Historic England

21 November 2018

**Re: A30 Chiverton Cross to Carland Cross TR010026**

Drawing Title: **FIGURE 2.1 GENERAL ARRANGEMENT PLANS SHEET 1 OF 8**

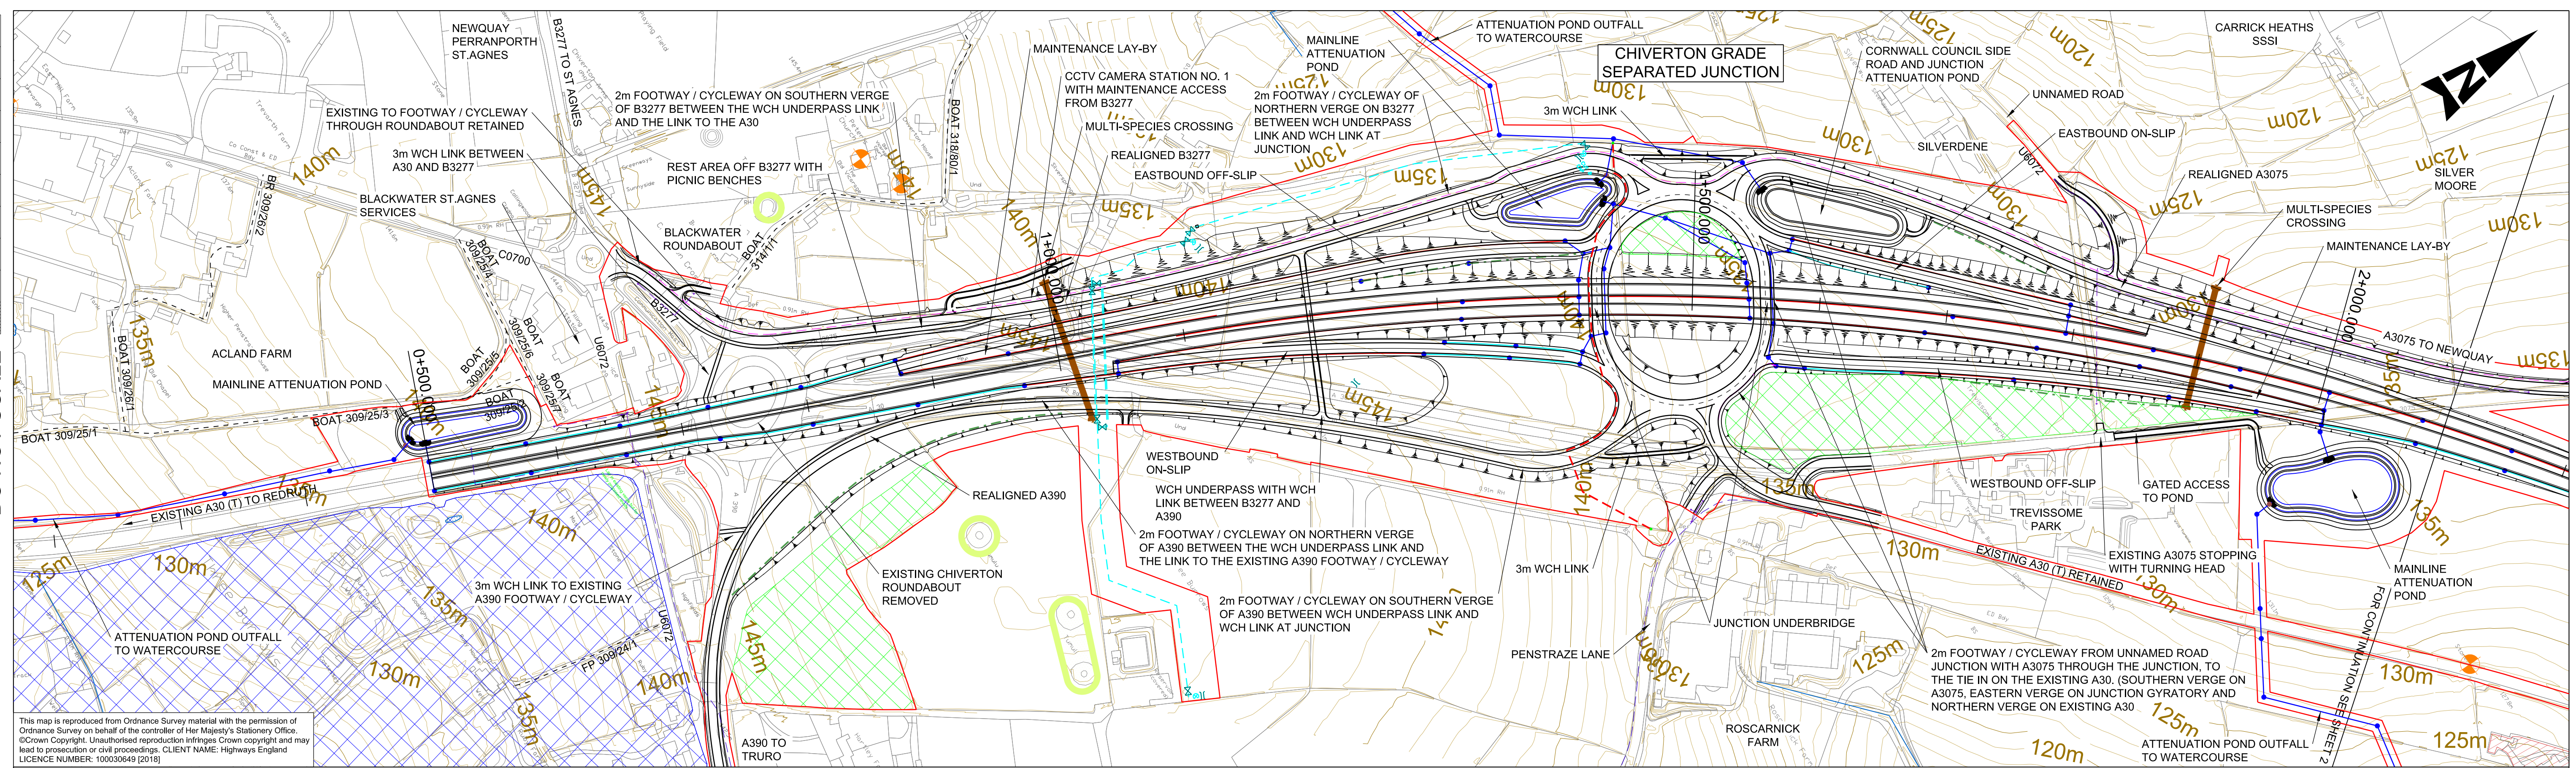
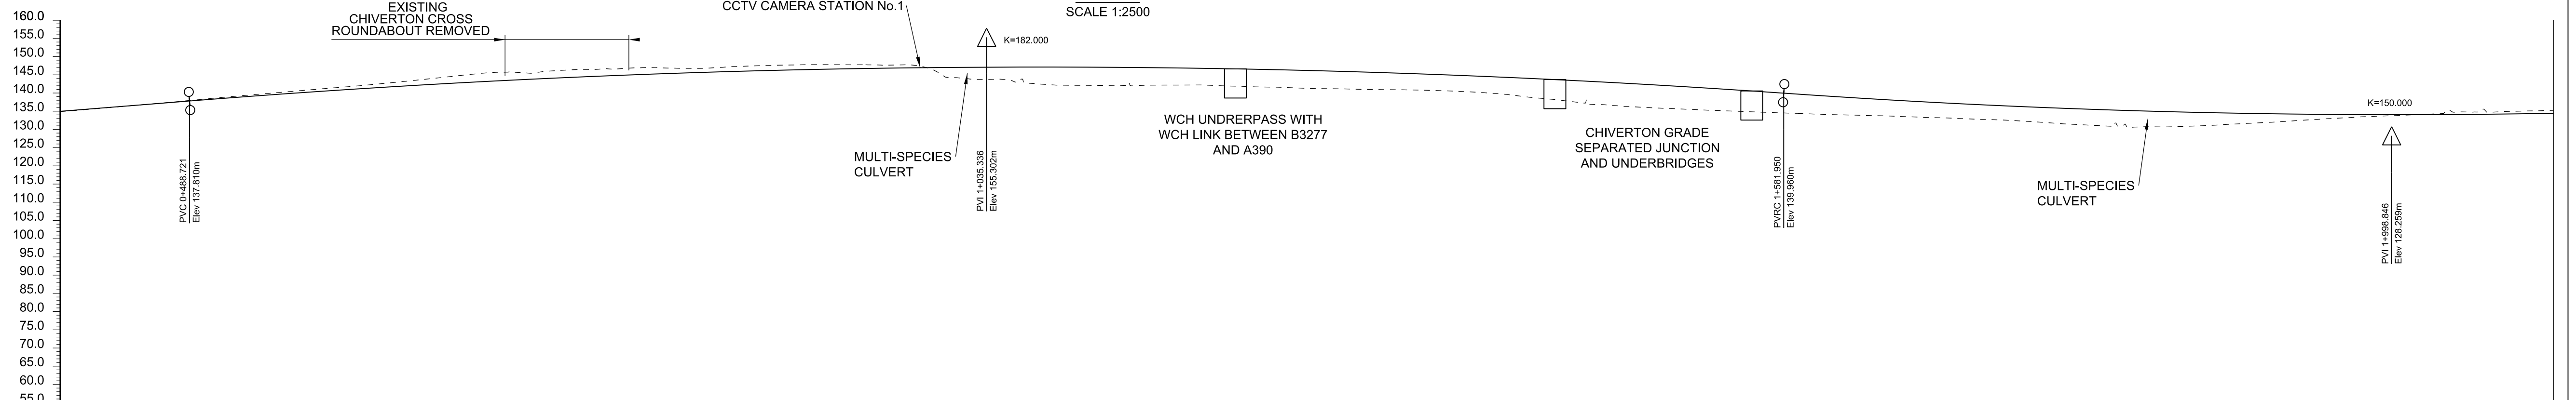
**Chiverton Cross area.** Historic England remains concerned regarding the impact of the proposed new junction on views of the church of St Peter (NHLE no. 1141481), particularly from the north and east. This significantly reduces the ability to 'read' the historic importance of the church as a landscape feature and we would recommend that close scrutiny be applied to the engineering options for the new junction.

Drawing Title: **FIGURE 2.1 GENERAL ARRANGEMENT PLANS SHEET 8 OF 8**

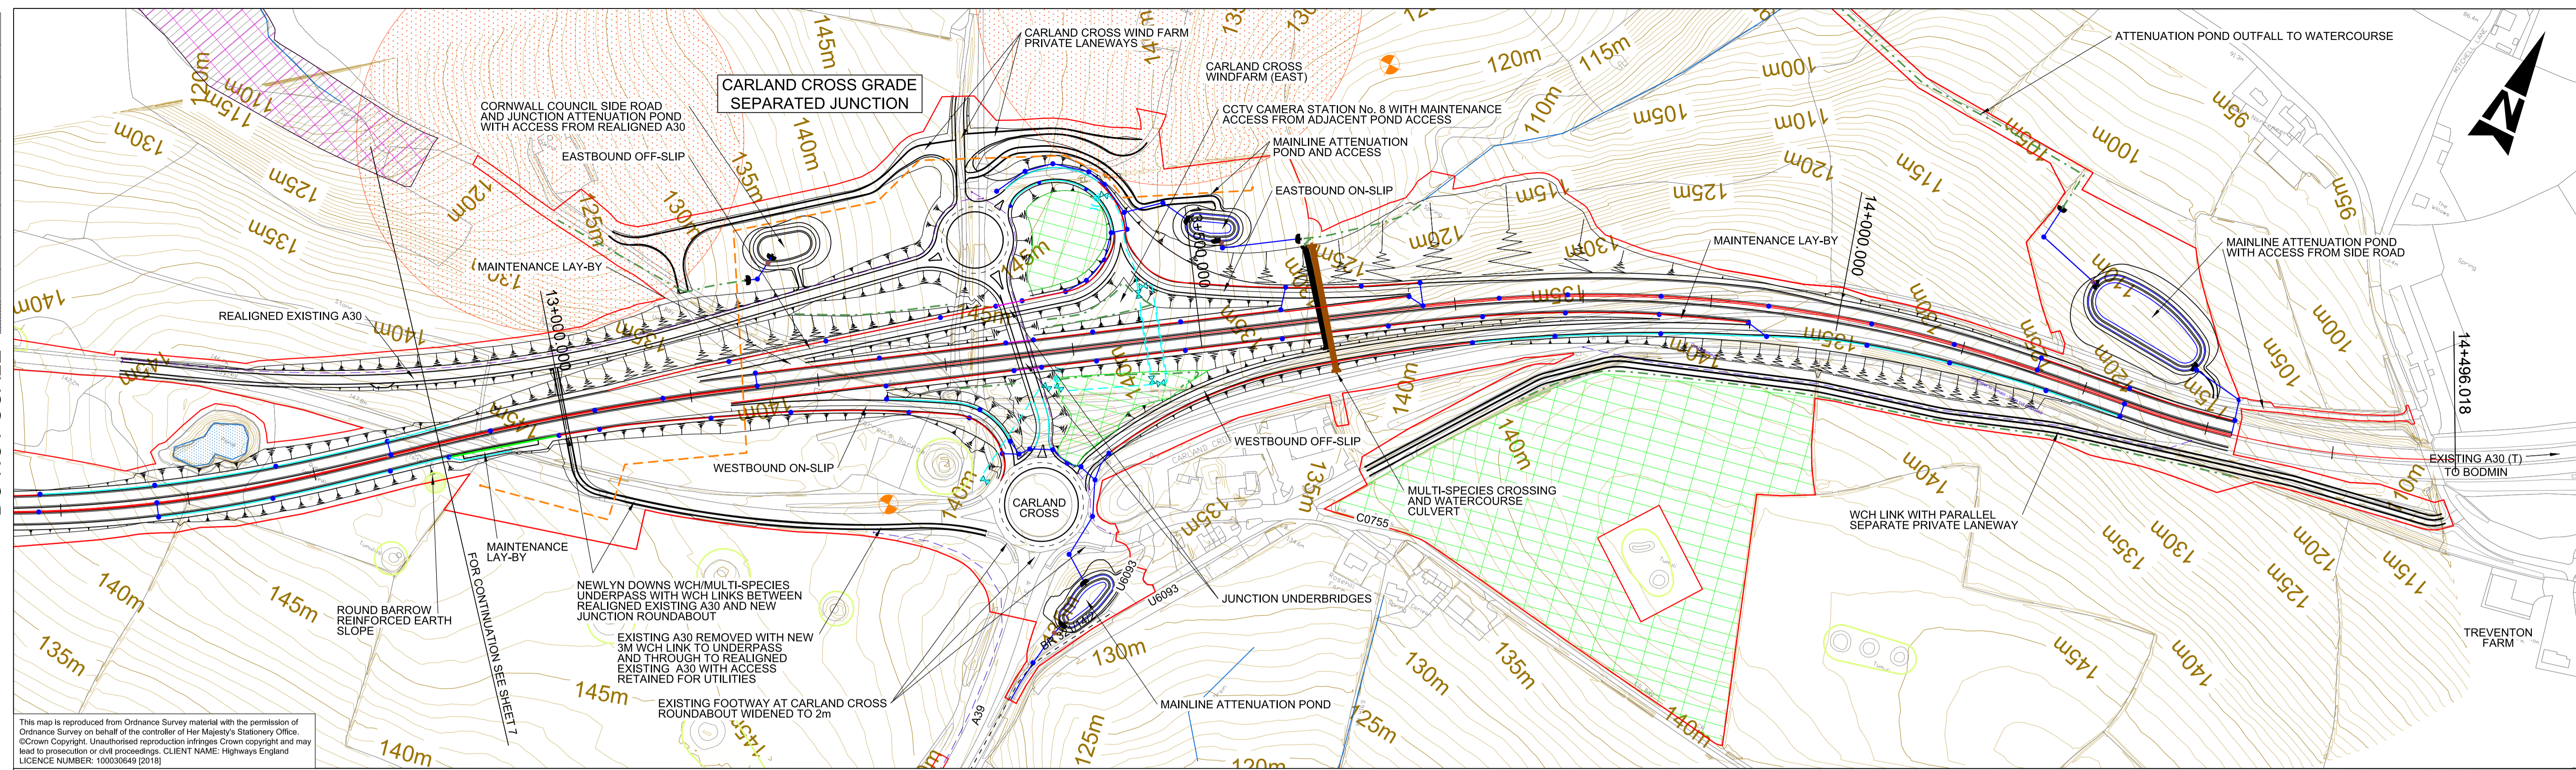
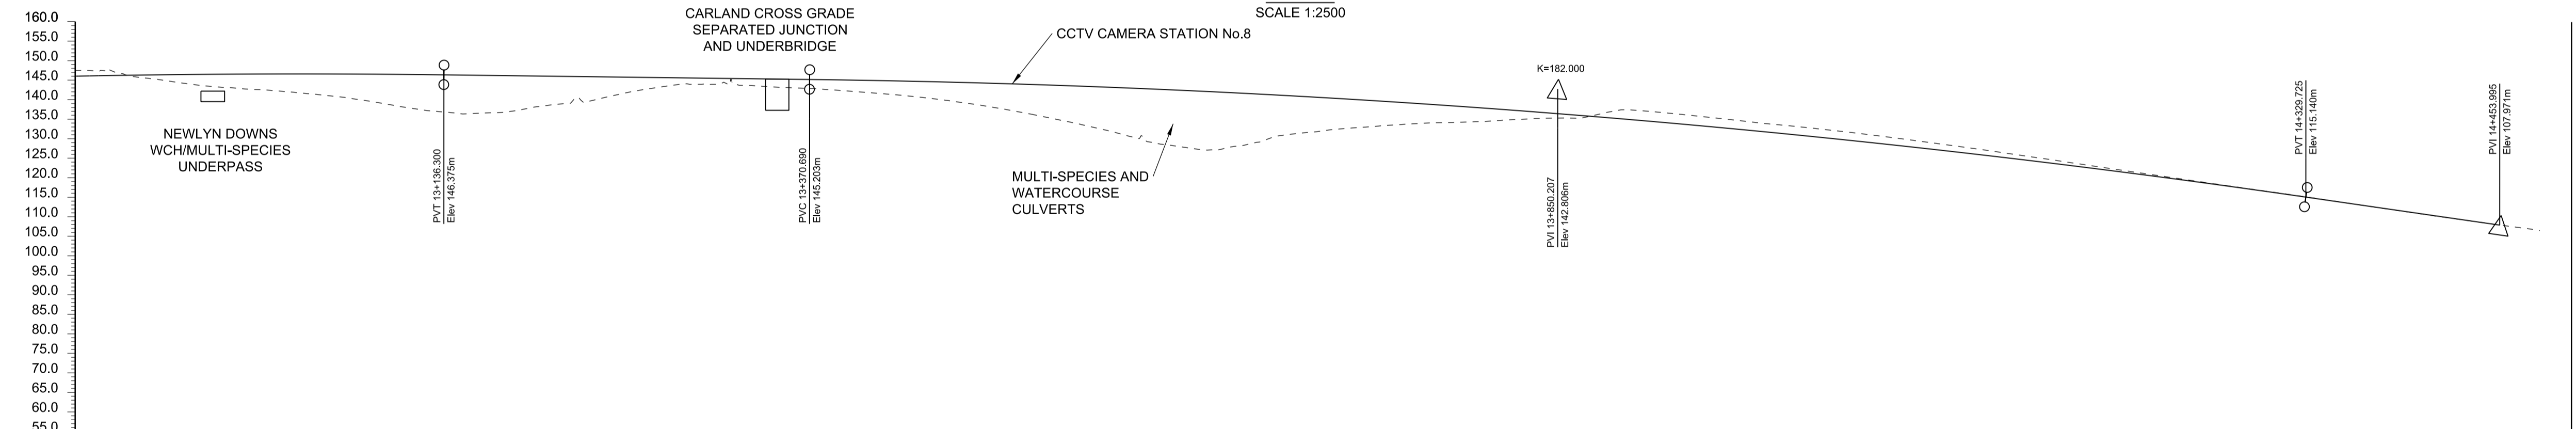
**6.11.72. Warrens barrow (SM 29681; NHLE 1016888).** In our opinion the significant issue here is the loss of views to, and from, the barrow to the north and west. Distant views are an essential factor in the location of barrows such that the loss of such visibility will result in loss of significance derived from this aspect of the barrow's setting. This loss of significance must be appropriately appreciated and should not be underestimated, but also considered separately initially from the undoubted gains in enhancement of the barrow's setting to the south that will arise from the removal of this section of the existing A30. Whilst we do not disagree with the assessment that "While the reuniting of Warrens Barrow with the barrow cemetery to the south is a beneficial impact, it is considered that this is outweighed by substantial changes within the setting of the barrow to the west, north and east.", we do, however, advise that the overall impact should be considered Large Adverse impact rather than Moderate.

**Warrens barrow (SM 29681; NHLE no. 1016888) and Round barrow cemetery 420m north-east of Higher Ennis Farm (SM 32903; NHLE no. 1020758).** We welcome the removal of the existing A30 from between these two separately designated elements of the round barrow cemetery at Carland Cross. This will reinstate the overall connectivity of the cemetery and allow for an improved management regime for Warren's barrow. We would advise that a key deliverable public benefit in heritage terms from this scheme should be the removal of this monument from Historic England's Heritage At Risk register.

Historic England's main concern is that regardless of the issues outlined above, the current proposals for the new route will result in a very high level of harm to the significance of the Warrens barrow scheduled monument that will not, in our opinion, be sufficiently offset by the potential for benefits gained from re-unification of the cemetery. The location of barrows is a significant element of their importance, usually located for maximum impact and visibility in both long and short views, they provide and illustrate the importance of landscape to the life and burial practices of prehistoric peoples. Since, in Historic England's opinion, there remains potential for further discussion to identify alterations to engineering details that would reduce the level of harm caused we would recommend that the Examining Authority encourage the applicant to continue to pursue discussion regarding this element of the scheme with Historic England in the interest of reducing its environmental impact.

We have previously requested a detailed examination of the engineering options for this junction on the basis that relatively minor changes could potentially affect major impacts and reductions in harm in relation to this issue. We would recommend that the Examining Authority urge the applicant to undertake a serious engineering options appraisal regarding the levels at the proposed new Carland Cross junction. In addition we would recommend further consideration of whether there are opportunities to achieve better value for public money and at the same time a reduced environmental impact in heritage terms in the proposals for this junction.
